Response to Issues – City of Sydney

80-88 Regent Street, Redfern – SSD 7080

Initial submission

1 Winter 3pm Existing
0501 1: 1000@A1

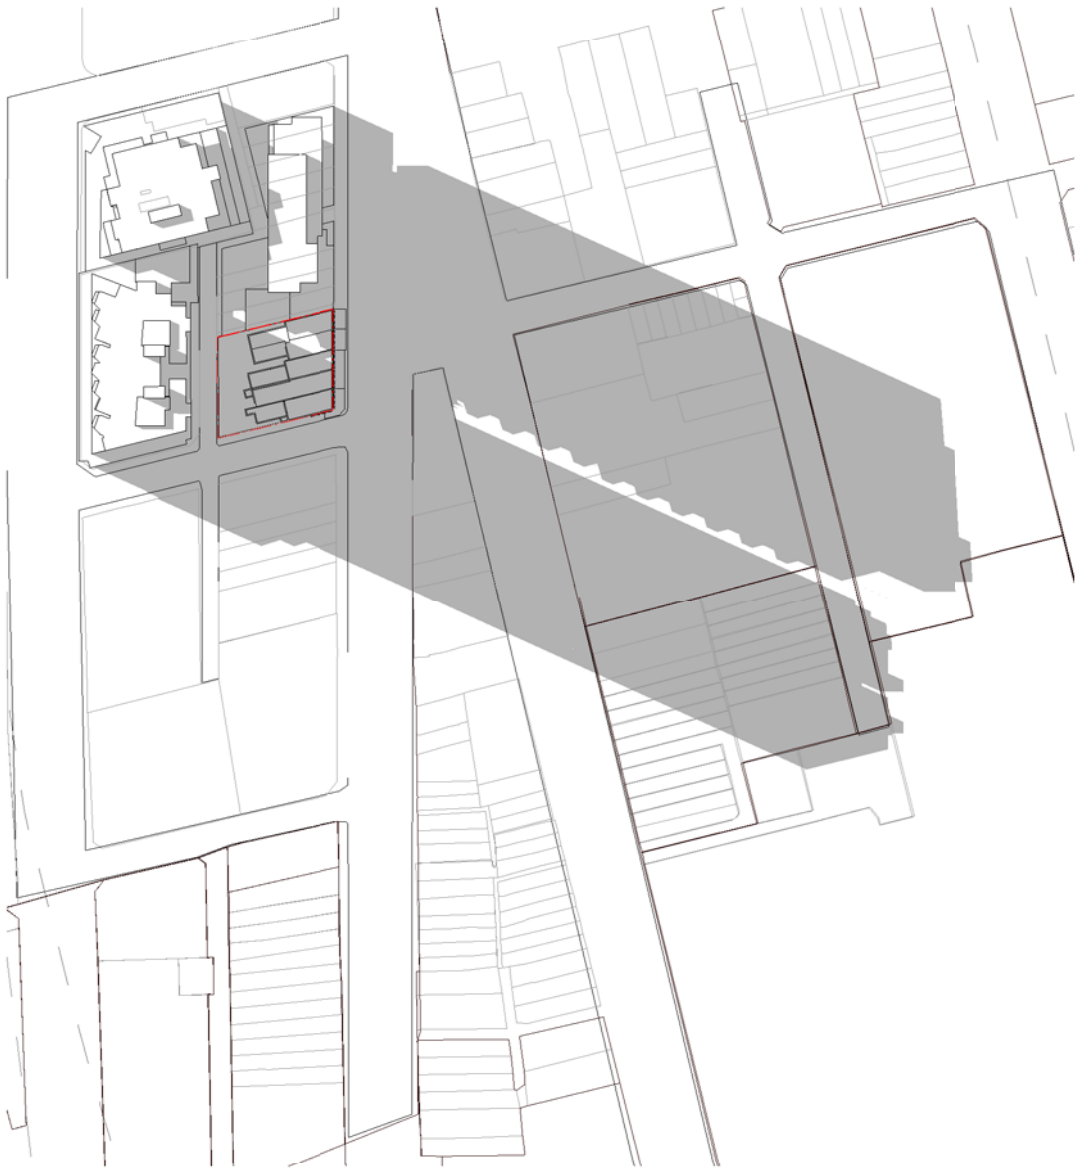
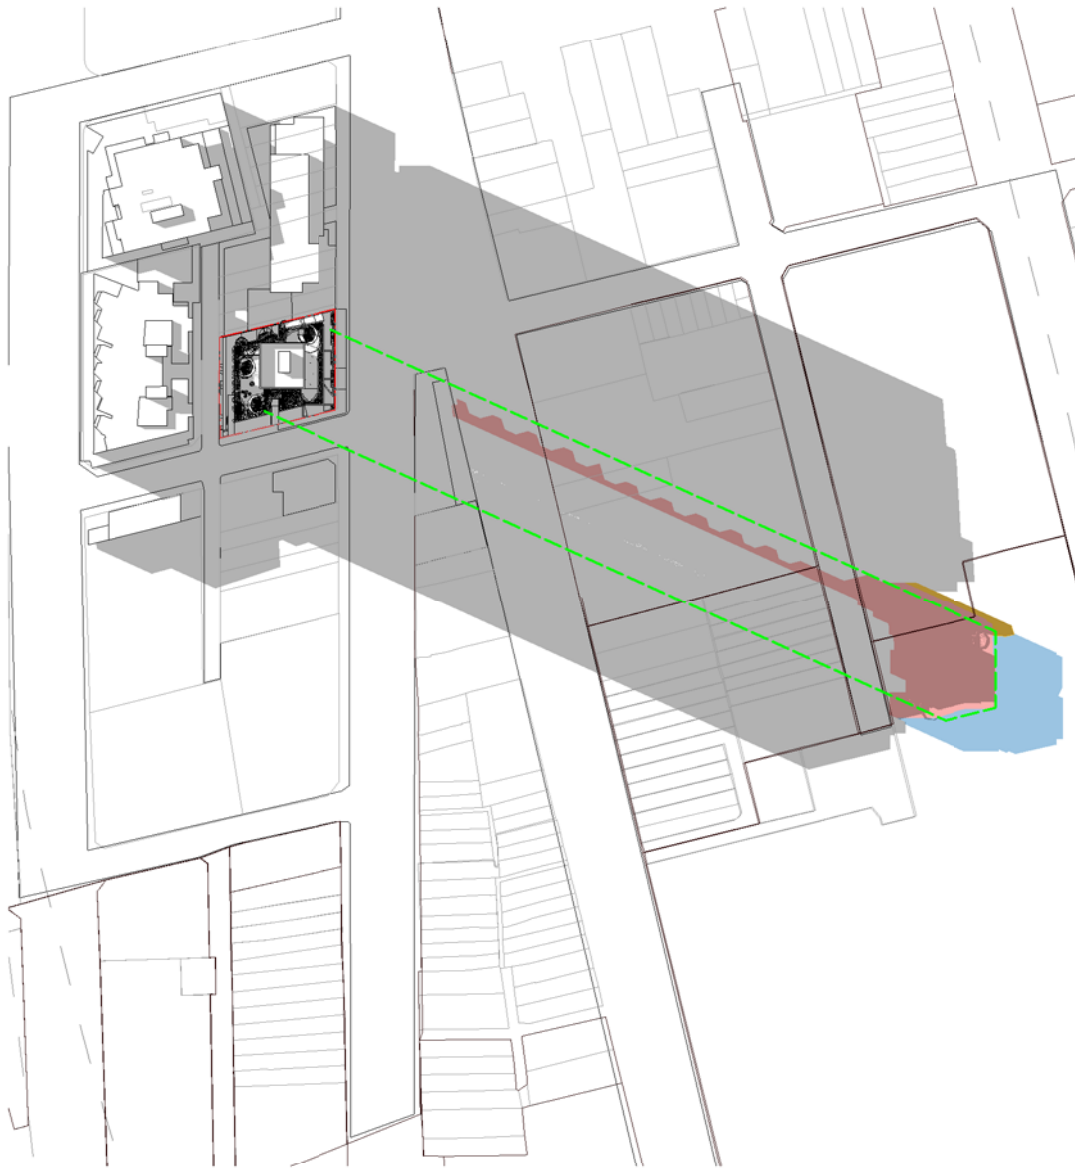
17. While the controls envisaged an 18 storey building, the proposal presents as a 20 storey building, increasing overshadowing impacts, particularly to the conservation areas between Cope and George Streets in the afternoon midwinter. There may also be additional view loss to residents in the adjoining residential building immediately to the east and northeast.	The height of the proposal has been reduced. The two mezzanine levels have been removed. Overshadowing analysis and an assessment of the impacts on views has been undertaken,	Refer to Sections 4.1, 4.7.1 and 4.7.2 and Architectural Drawing Package at Attachment 1

18. It is difficult to determine the extent of overshadowing and view loss that may be caused by the additional two storeys and lack of upper level setback. While the controls assume that there will be some impacts, the impacts should be limited to those anticipated by the controls.		
	<u>Recommendation</u> <ul style="list-style-type: none"> A careful review of the proposal is required to determine additional overshadowing and view loss impacts of the proposal as follows: <ul style="list-style-type: none"> ensure that there are no additional impacts created by the additional 2 storeys by comparing the proposal against a complying 18 storey scheme; ensure that there are no additional impacts created by the reduced upper level setback for Levels 15 to upper mezzanine by comparing the proposal against a complying setback scheme. 		
Podium design	19. The new podium proposes a series of five, large, high arches, which appear to be an interpretation of the existing 5 terrace buildings.	The podium has been modified.	Refer to Sections 2.2, 4.2.1, 4.6,
